Paul Grinyer Associates Ltd

7th May 2021

STRUCTURAL INSPECTION OF GARAGE BUILDING (UNIT 3) – CONVERSION OF 23 MEAD LANE, BOGNOR REGIS TO THREE RESIDENTIAL DWELLINGS

PARTIAL EXISTING NORTHERN ELEVATION

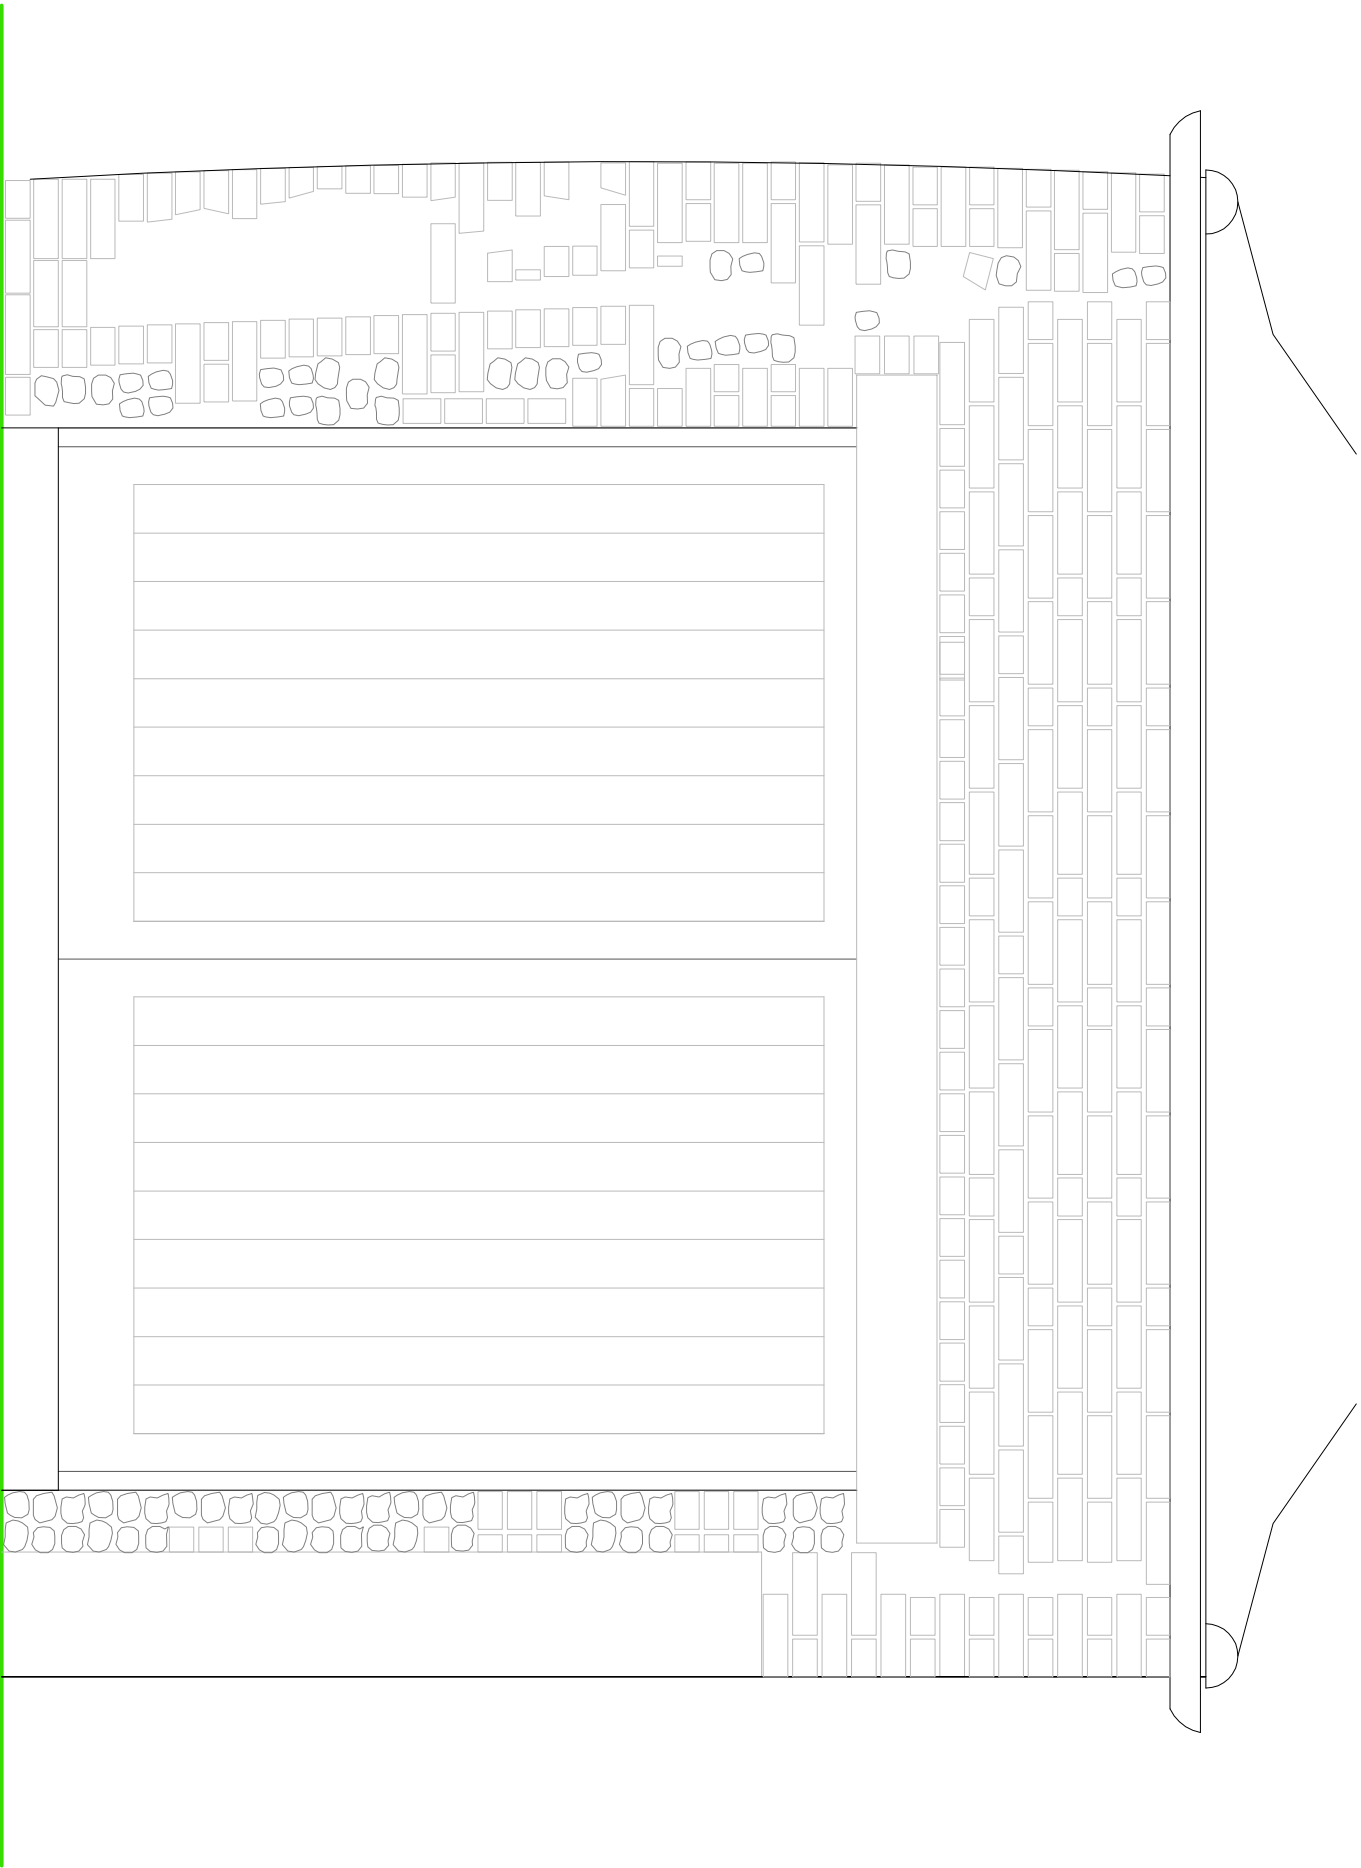
Having inspected the east and north elevations of the existing garage, we noted the brick quoin, to the north east corner of the garage structure was out of plumb and bowed vertically over the height of the building with cracking between it and the adjacent small sections of unbonded flint masonry and brickwork. In addition the 215mm solid brick wall over the existing garage doors was noted to have deflected and a vertical separation crack present to the east end at the abutment with the north east corner quoin.

The brick quoin was bonded to the flint masonry east external wall and poorly bonded to infill masonry and flintwork on the north elevation, around the garage door frame. The infill flintwork and brickwork was not original to the structure and a later addition.

The pre-existing movement to the existing brick quoin to the north east corner is such that it will not be possible to bond new brickwork to it whilst maintaining the correct lines and levels for the north elevation masonry. In addition, from our recent inspection, it is not considered possible to bond any new brickwork to the already deformed existing masonry on the north elevation and which includes the infill brick and flintwork. Any attempt at doing so will destabilise the wall and corner of the building further. In addition the masonry over the garage door has moved and is unlikely to be able to be safely supported in the temporary condition without risk of partial or total collapse.

In order to safeguard the longer term stability of the garage structure and to extend its longevity for the foreseeable future we strongly recommend that the existing brick quoin to the north east corner of the garage structure is rebuilt in its entirety, returning this along the north elevation and replacing poorly formed and structurally unsound flint and brick infill. The masonry over the garage doors should also be rebuilt in order to provide a robust and stable structural arrangement. The existing flint and brick elements cannot be retained as to do so will leave the structure in an inadequate structural condition and at risk of potential further movement or collapse. The rebuilding and remedial work could be achieved by reusing some existing materials or similar reclaimed materials.

PARTIAL PROPOSED NORTHERN ELEVATION

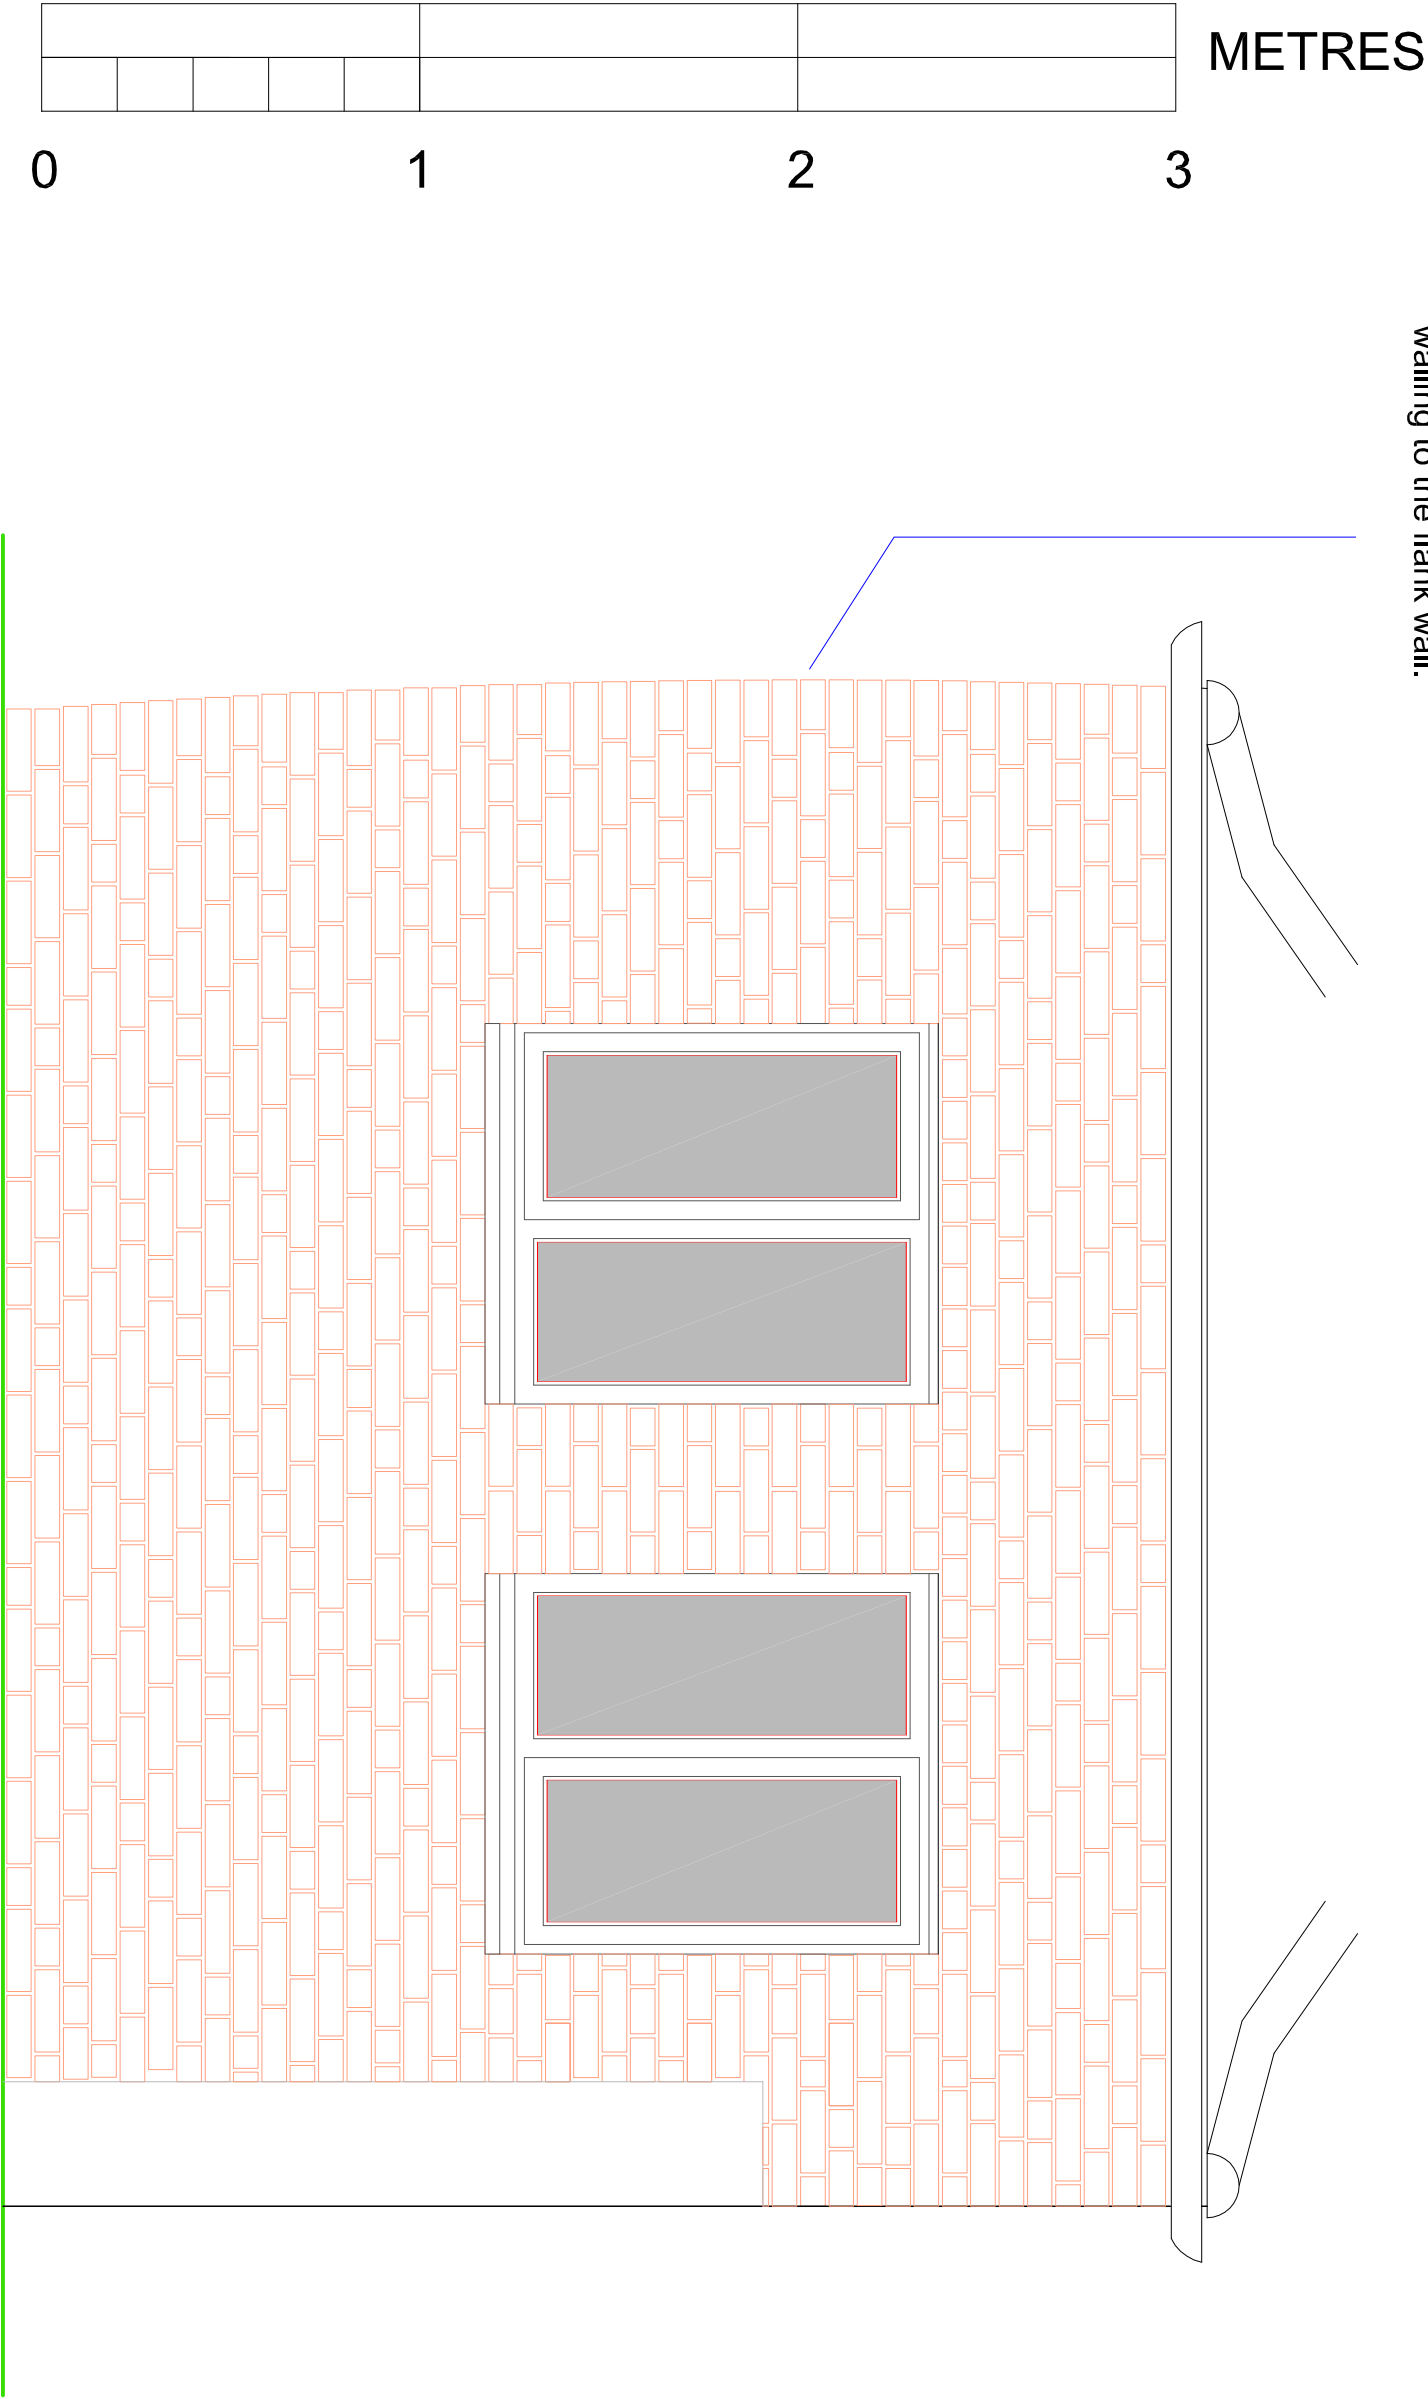
The works proposed to the north elevation will require installation of two new windows, with brick surrounds and a central pier between them. The brickwork to the sides of the windows will need to be bonded to the existing masonry to ensure adequate stability. This cannot be achieved by bonding to the poorly formed flintwork, which is in a deteriorated condition.

Without undertaking the works recommended above the stability of the north and east elevations of the structure will be compromised possibly resulting in further movement and even partial collapse. Undertaking the recommended works as part of the proposed conversion work will, in our considered opinion, provide a robust structural form which should not require further repair in the medium term future, thus securing that part of the building for the future and maintain the built heritage of the rest of the structure without need for more significant remedial work.
